DOC16/421017-2  
SSD 5144 (MOD 2)

**RE: MANDALONG SOUTHERN EXTENSION PROJECT - SSD 5144 (MOD 2) - FIRST WORKINGS  
MODIFICATION FOR LONGWALLS 22 & 23**

## **ATTACHMENT 1: OEH REVIEW OF MANDALONG SOUTHERN EXTENSION PROJECT (MOD 2)**

Figure 2: ~~Approved Conceptual~~ Mine Plan

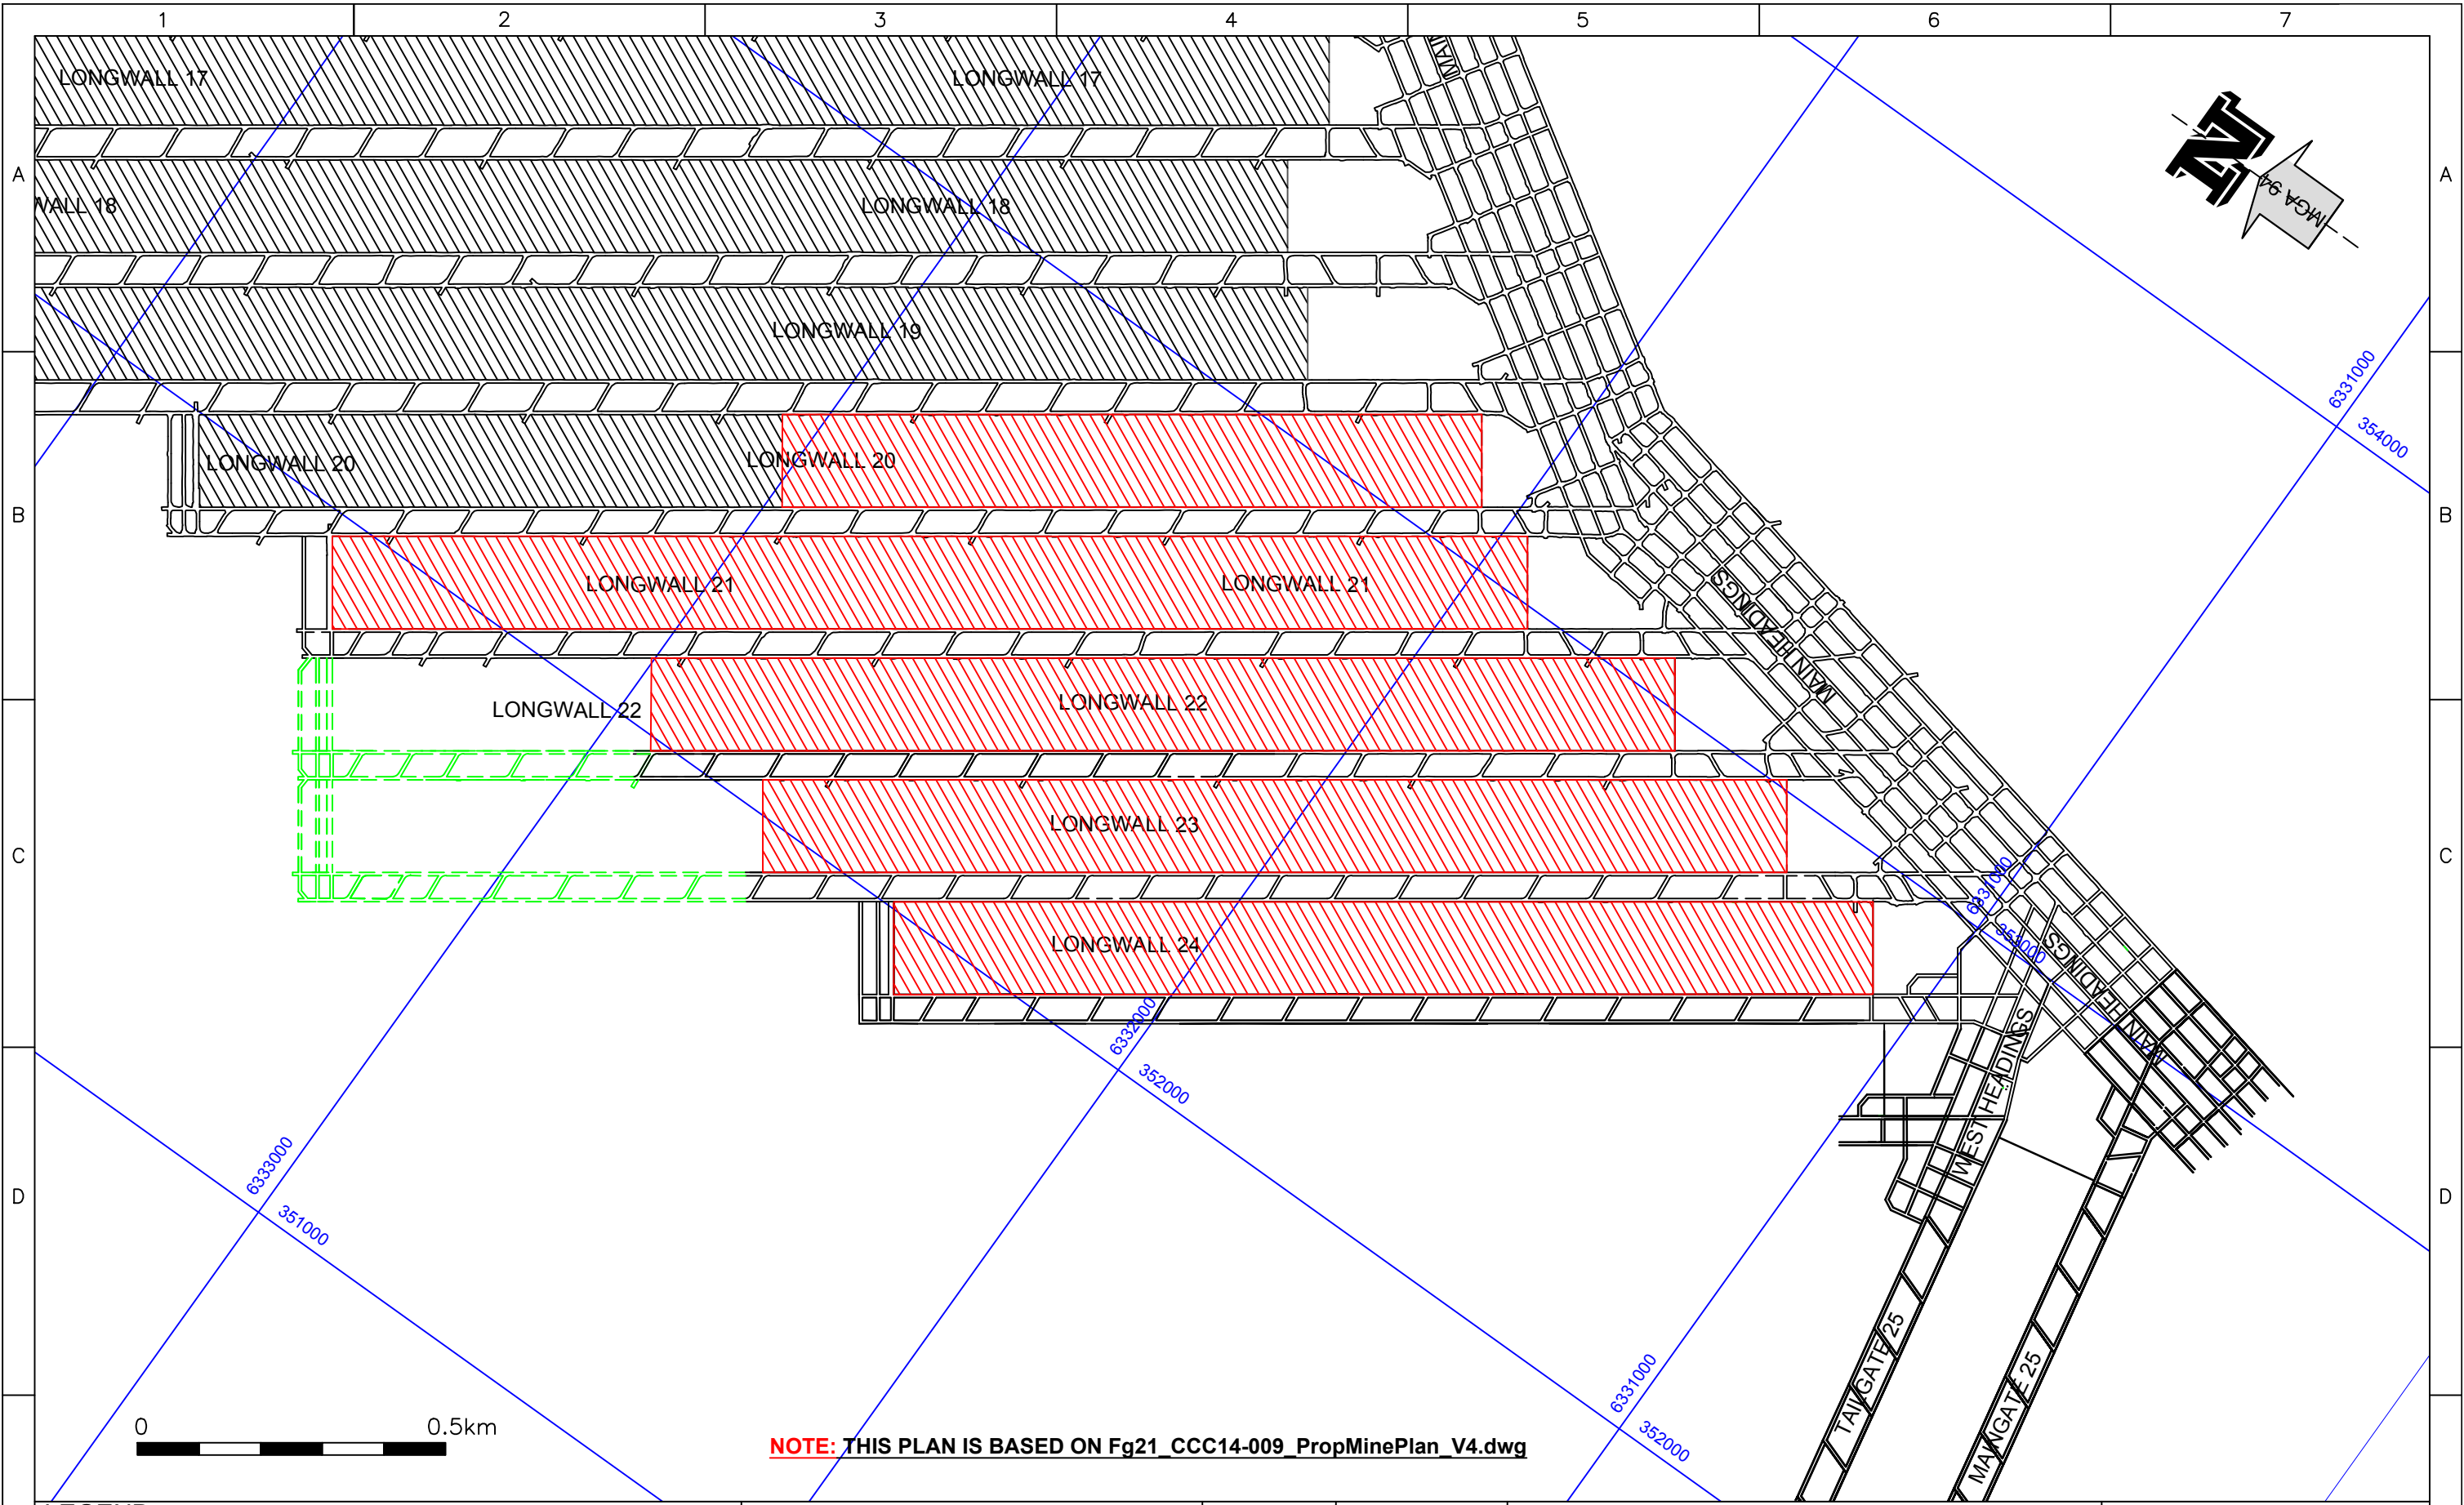
A general comment on the proposed amendments to the consent conditions provided Appendix C of the SEE is that OEH does not support the proposal to modify the consent to allow development to be carried out "*generally in accordance*" [with the consent] and the "*conceptual mine plan*" (SEE, Section 4, p. 5). This would significantly weaken the consent authority's capacity to audit or conduct compliance on the consent.
